RFI #: 49
 Date: 2/3/2012
 Job: EB-02 Keller Springs Lofts
 Phone: 877-777-5115

Subject: thickened beam wall rebar requirements

RFI #: 59
 Date: 2/21/2012
 Job: EB-02 Keller Springs Lofts
 Phone: 877-777-5115

RFI #: 172
 Date: 7/11/2012
 Job: EB-02 Keller Springs Lofts
 Phone: 877-777-5115

SG3.02

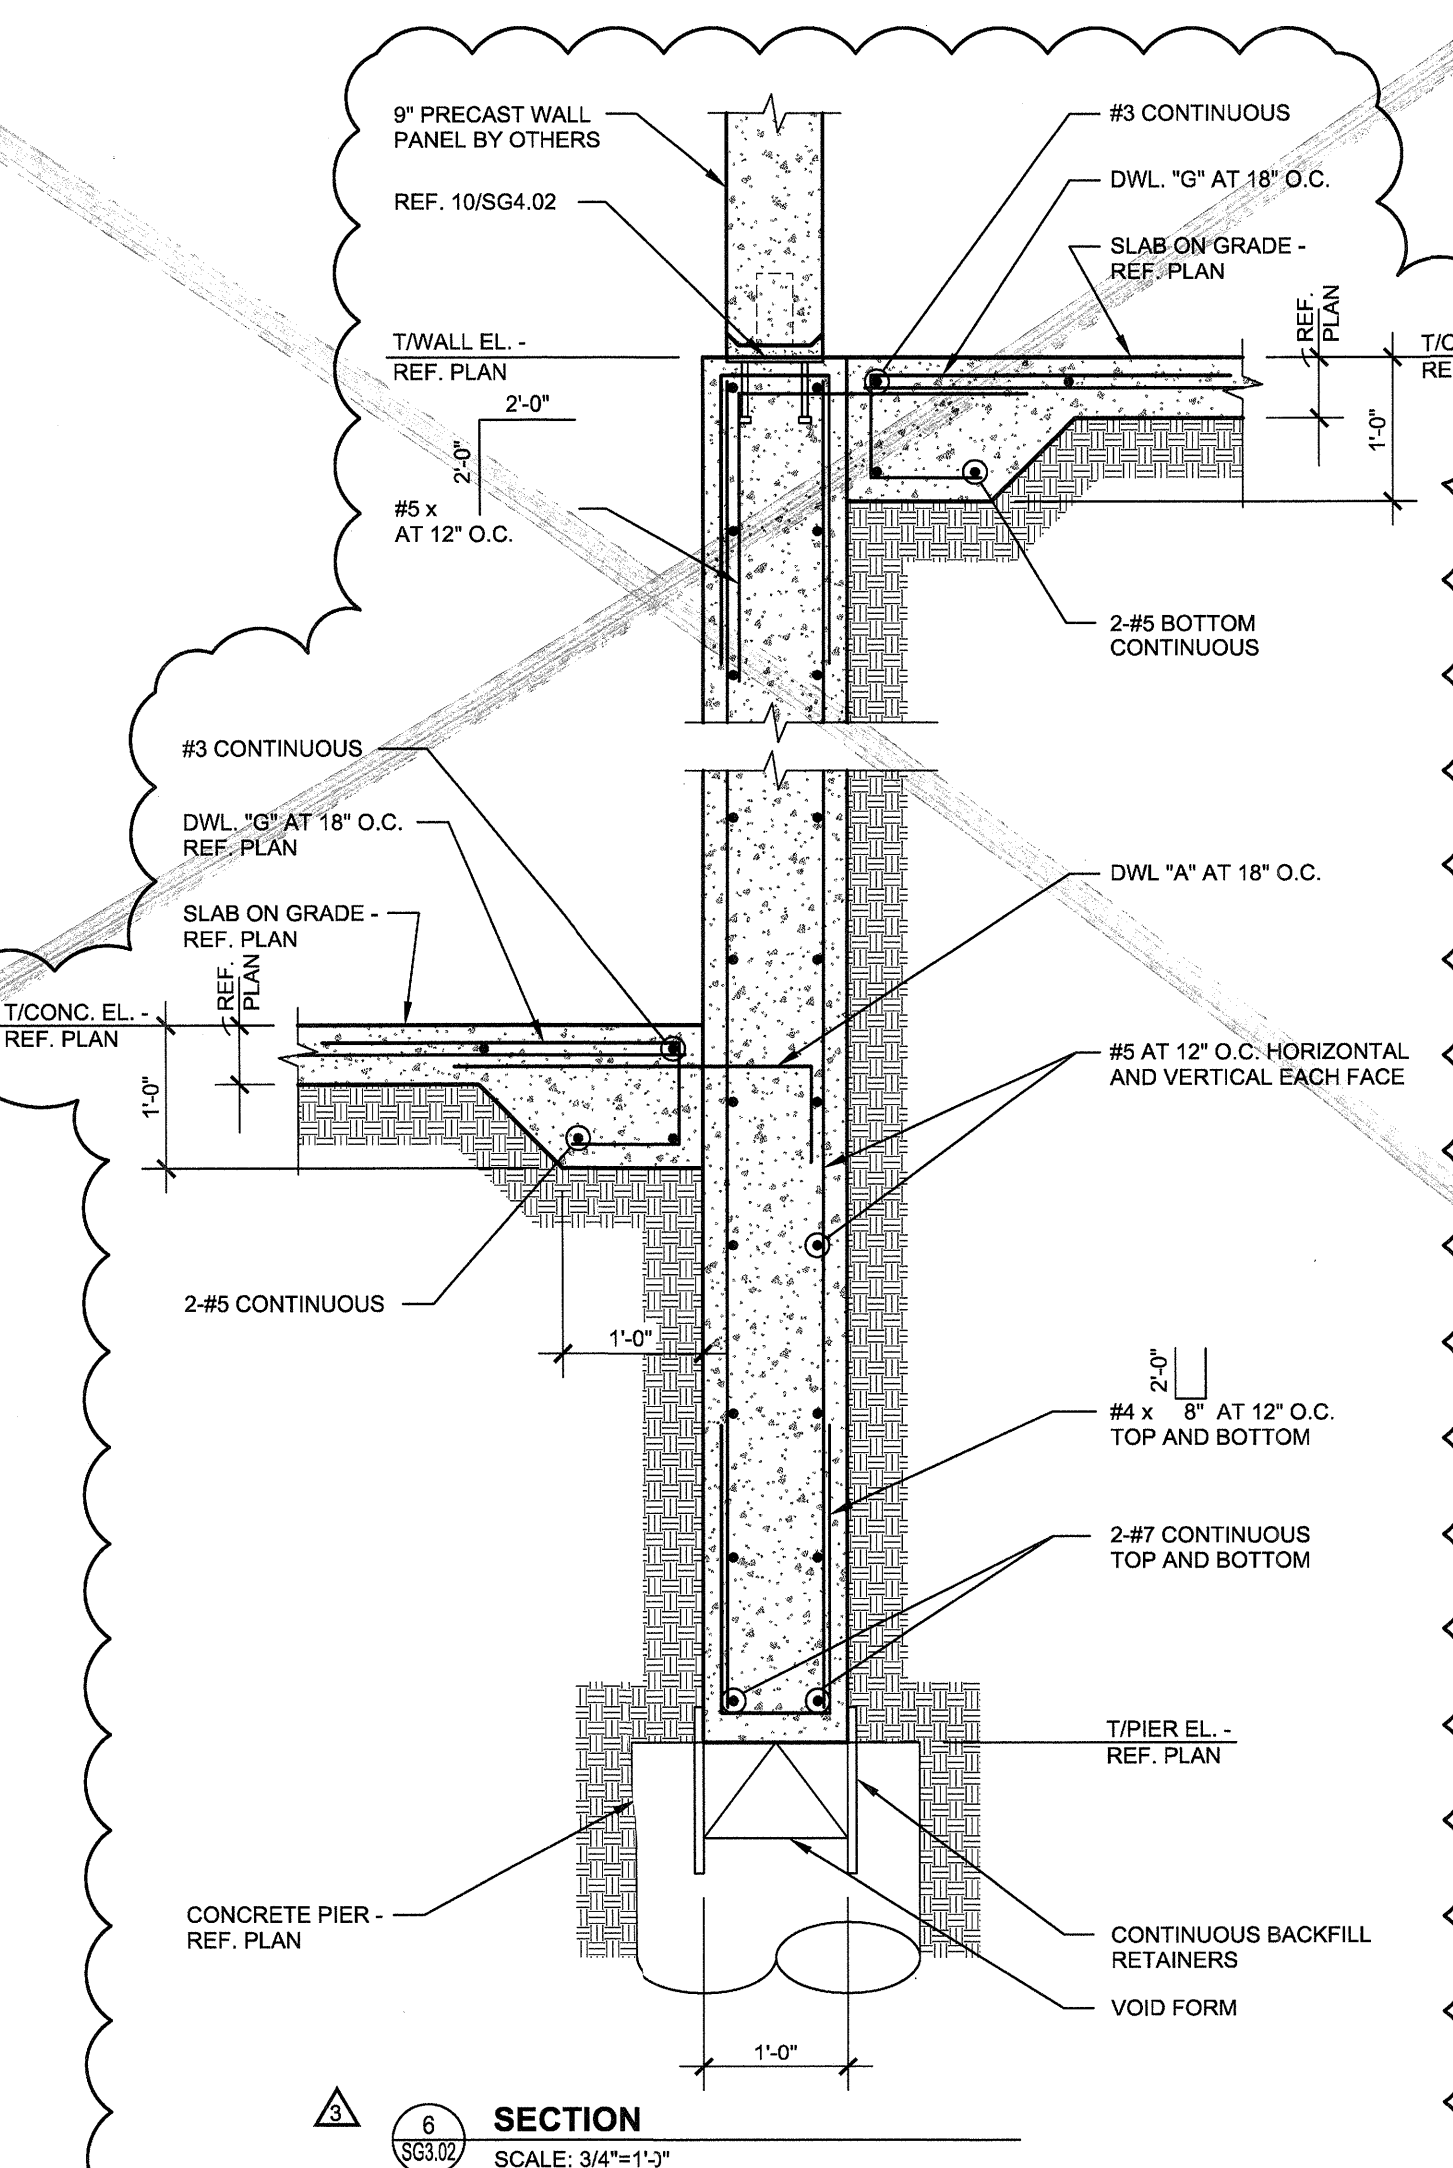
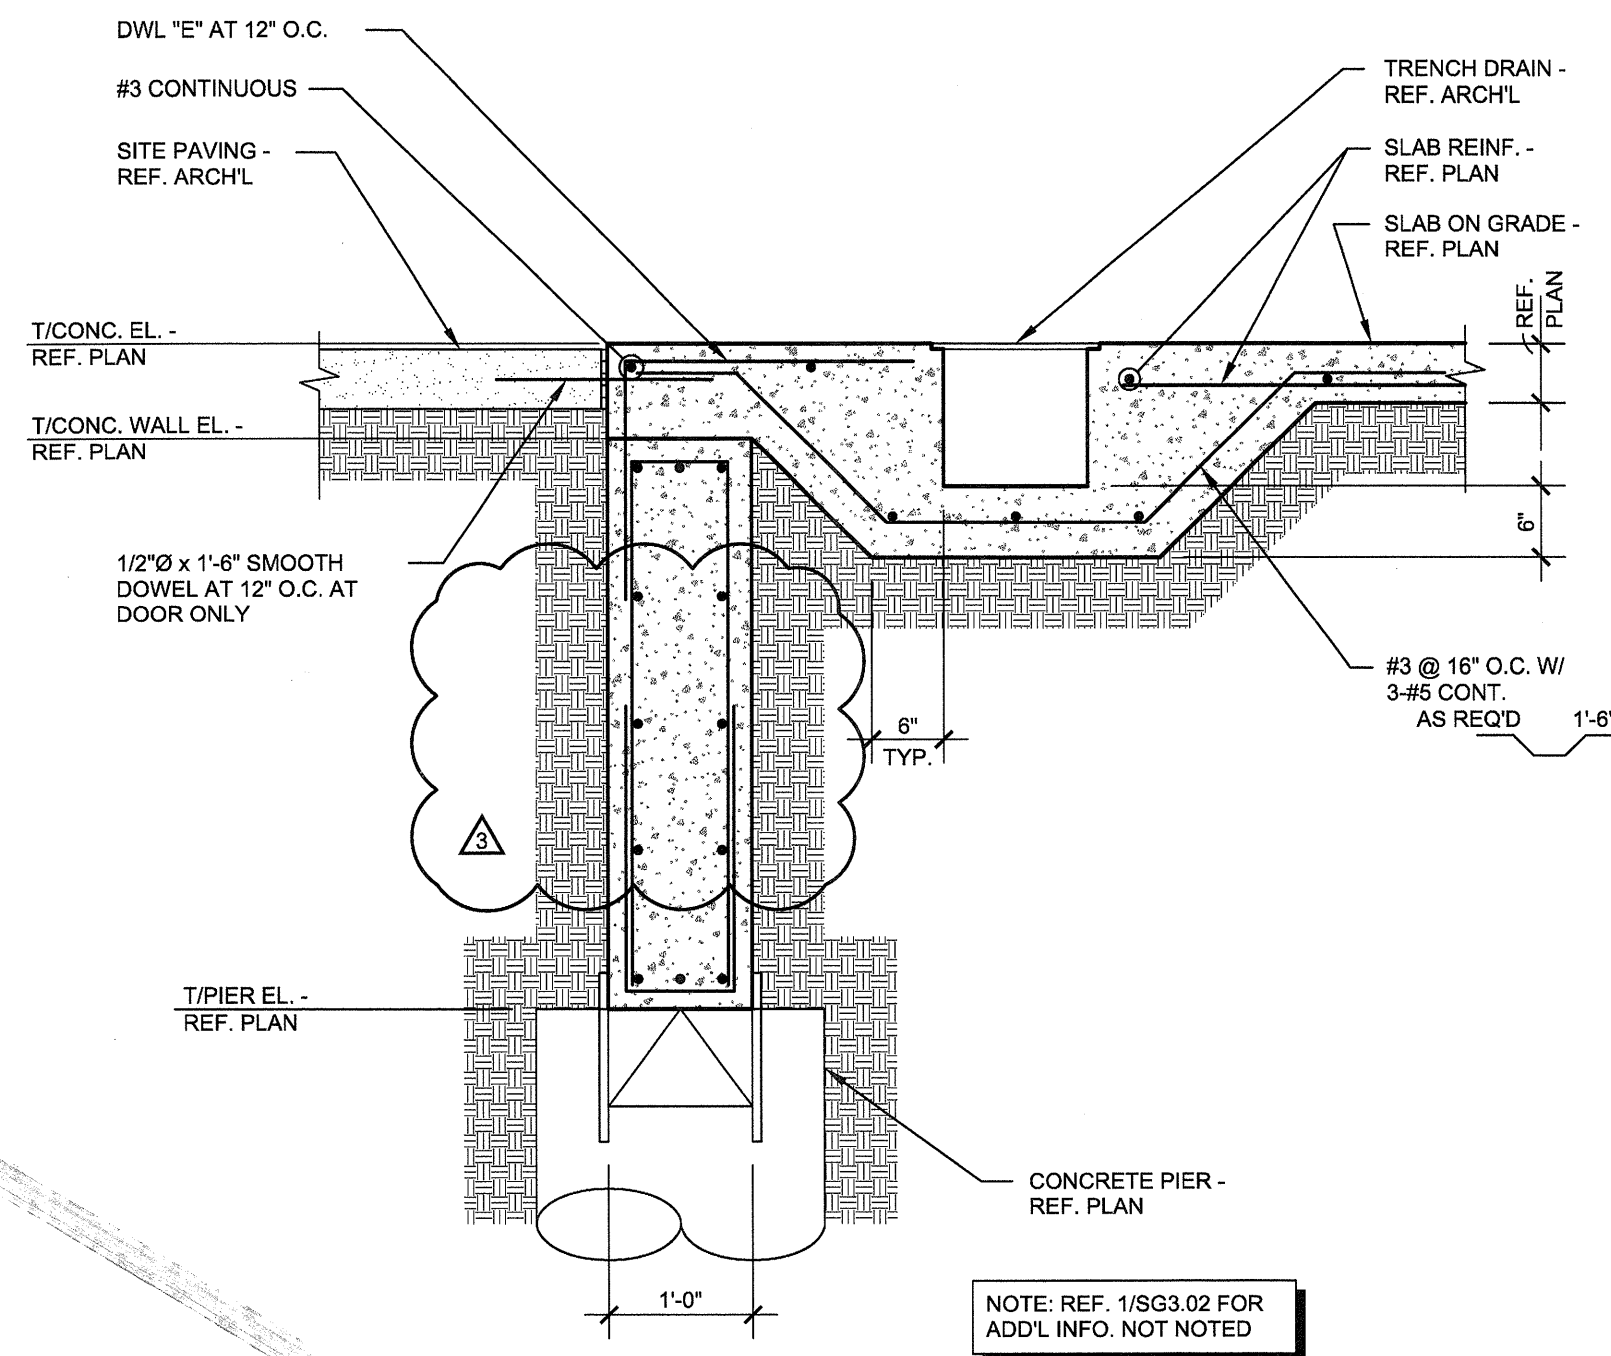
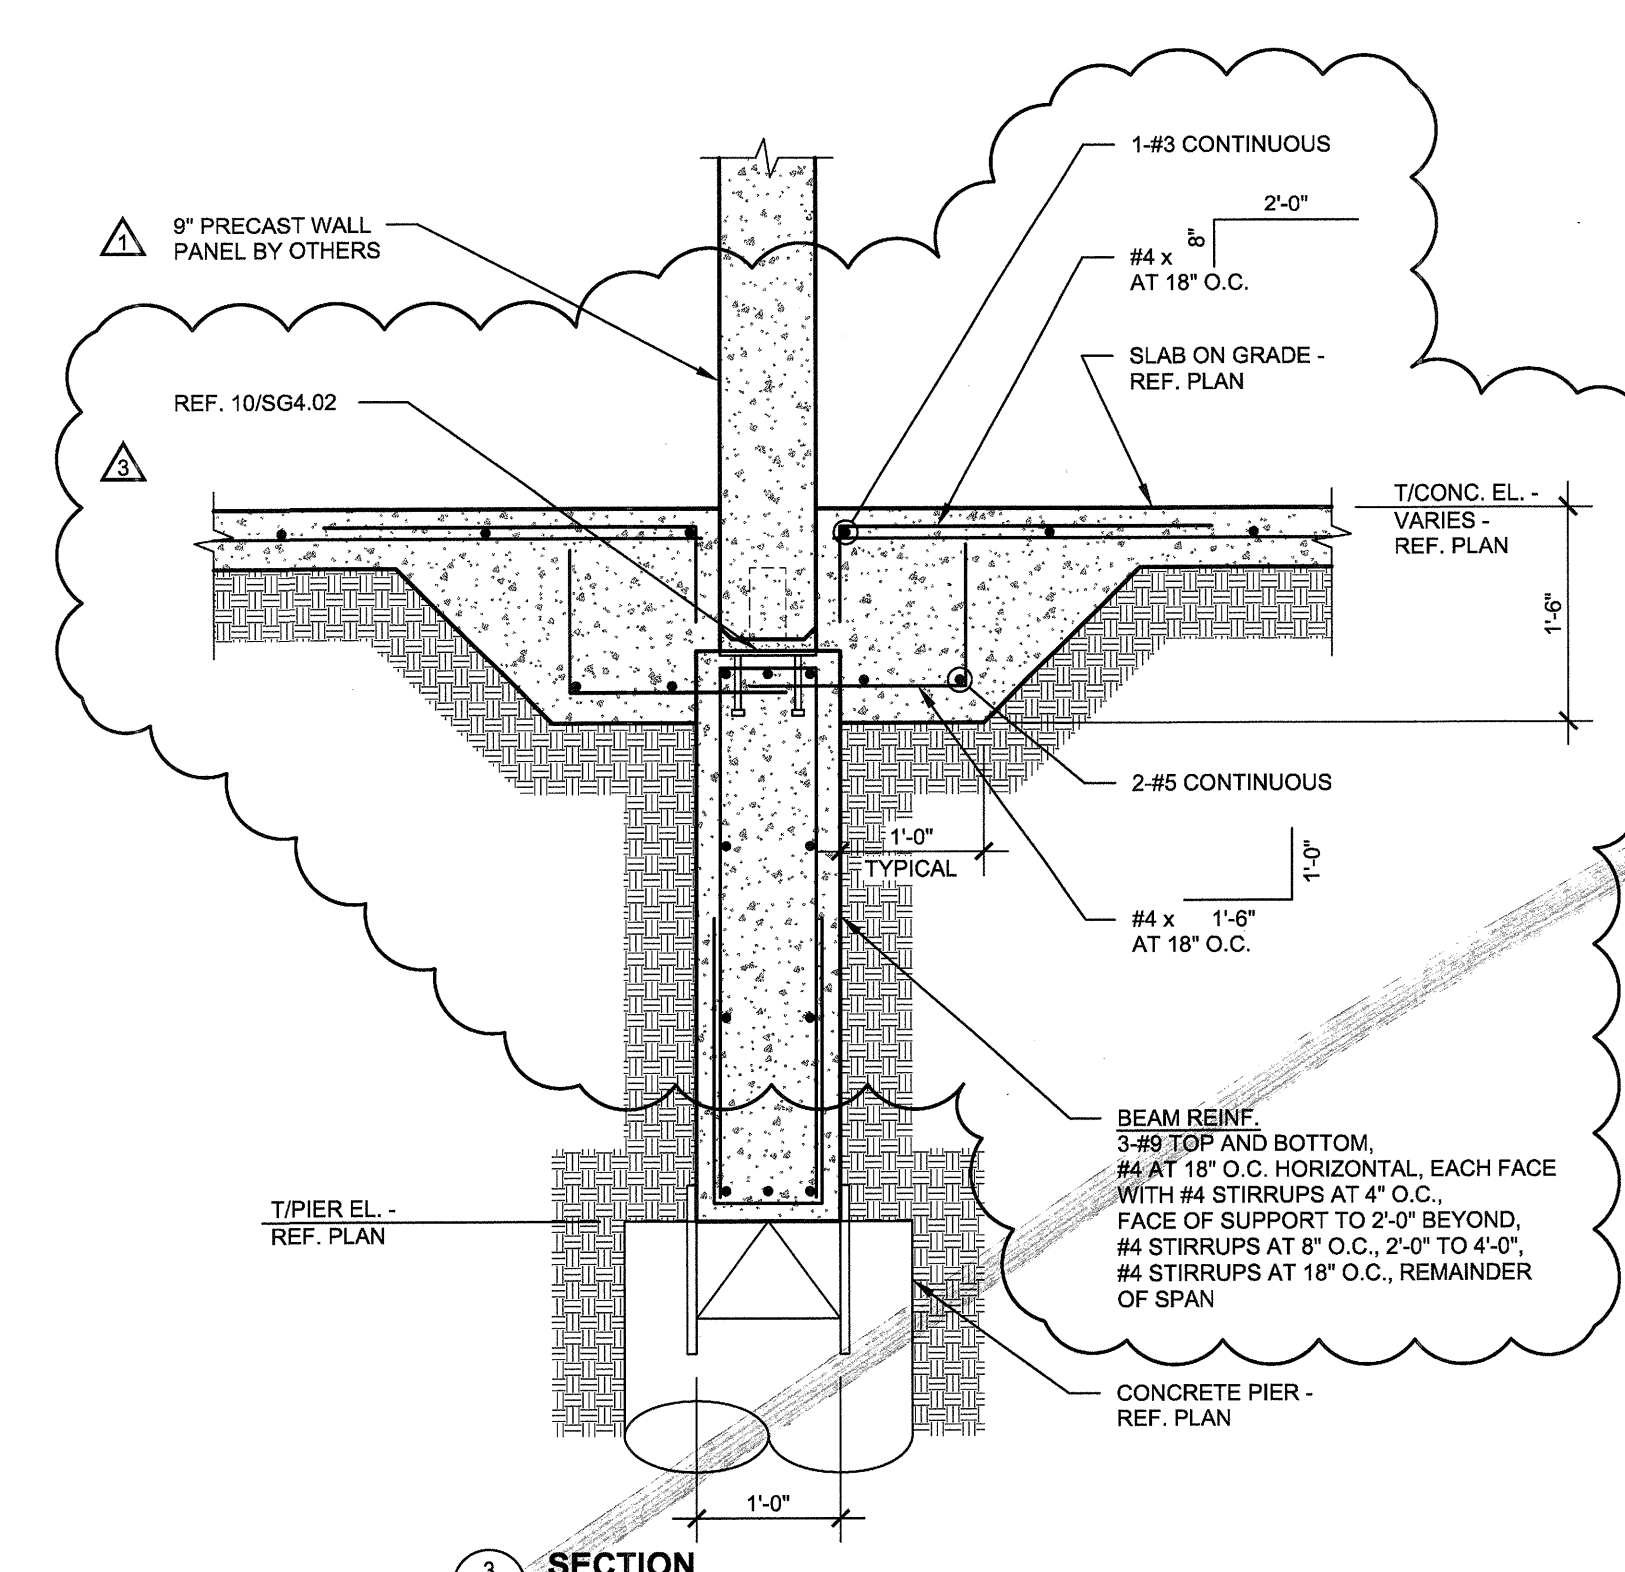
Request:
 As per East Texas Pre-cast we are going to provide a 2' leave out around the perimeter of the garage slab where connecting the pre-cast panels is required. We need a detail with steel requirements and thicker slab dimensions (if any). For this application East Texas Pre-cast is also requiring a 5' block out at columns we need a detail for it if it is different from the typical 2' leave out.

- At the two foot leave out, thickened slab edge requirements shall be as indicated in the details on sheet SG3.02. The slab reinforcement shall be in accordance with the details on sheet SG3.02 and continue across the joint and into the leave out. Tool and seal the joint at the leave out.
 - Please refer to the attached sketch for the detail at the column block outs.
- If you have questions or require additional information regarding this matter, please do not hesitate to contact us.

SECTION 8
NO SCALE

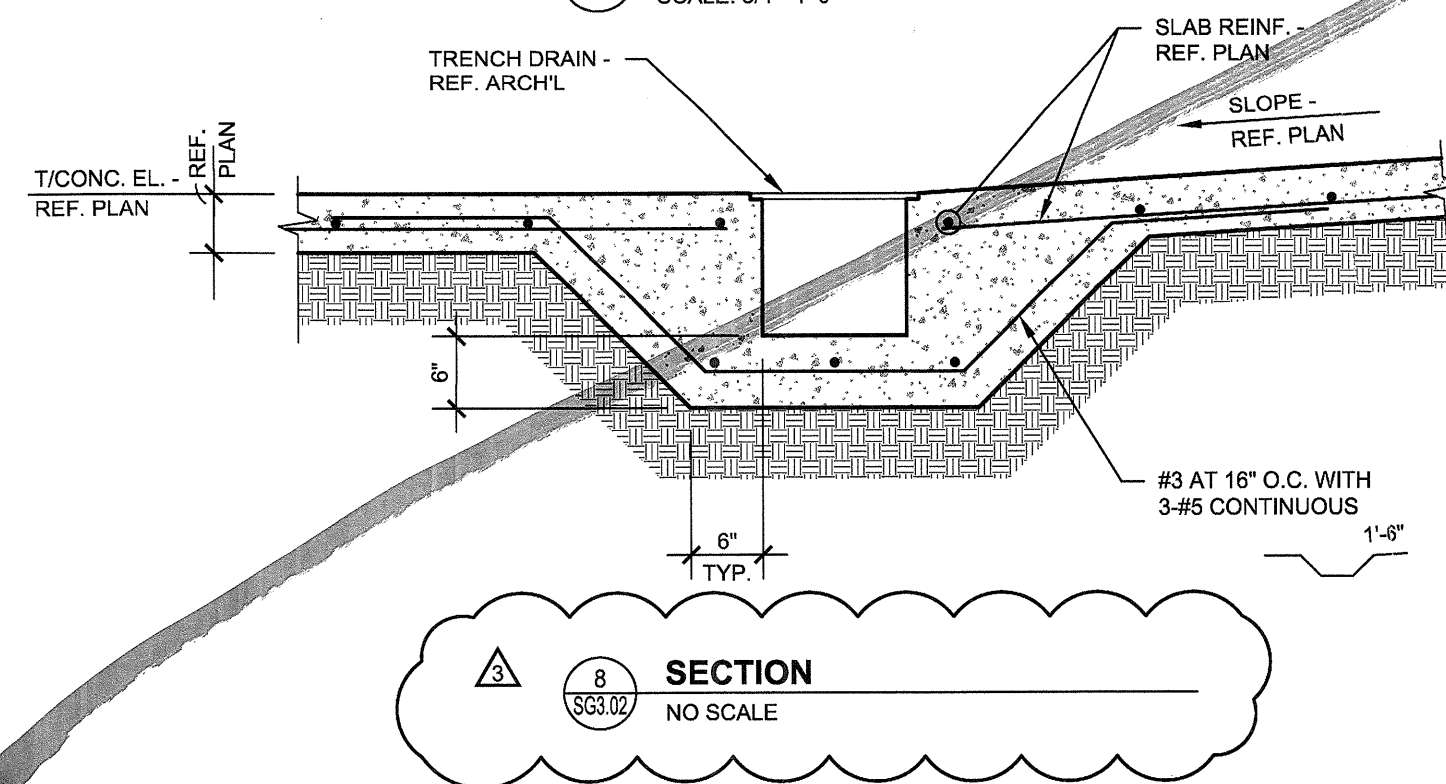
Request:
 East Texas Precast calls for a 5' x 5' x 3/8" angle iron per the attached detail. Please confirm that this is the size that you prefer.

EAST TEXAS PRECAST IS RESPONSIBLE FOR THE DESIGN OF THIS ITEM. PPO TAKES NO EXCEPTION
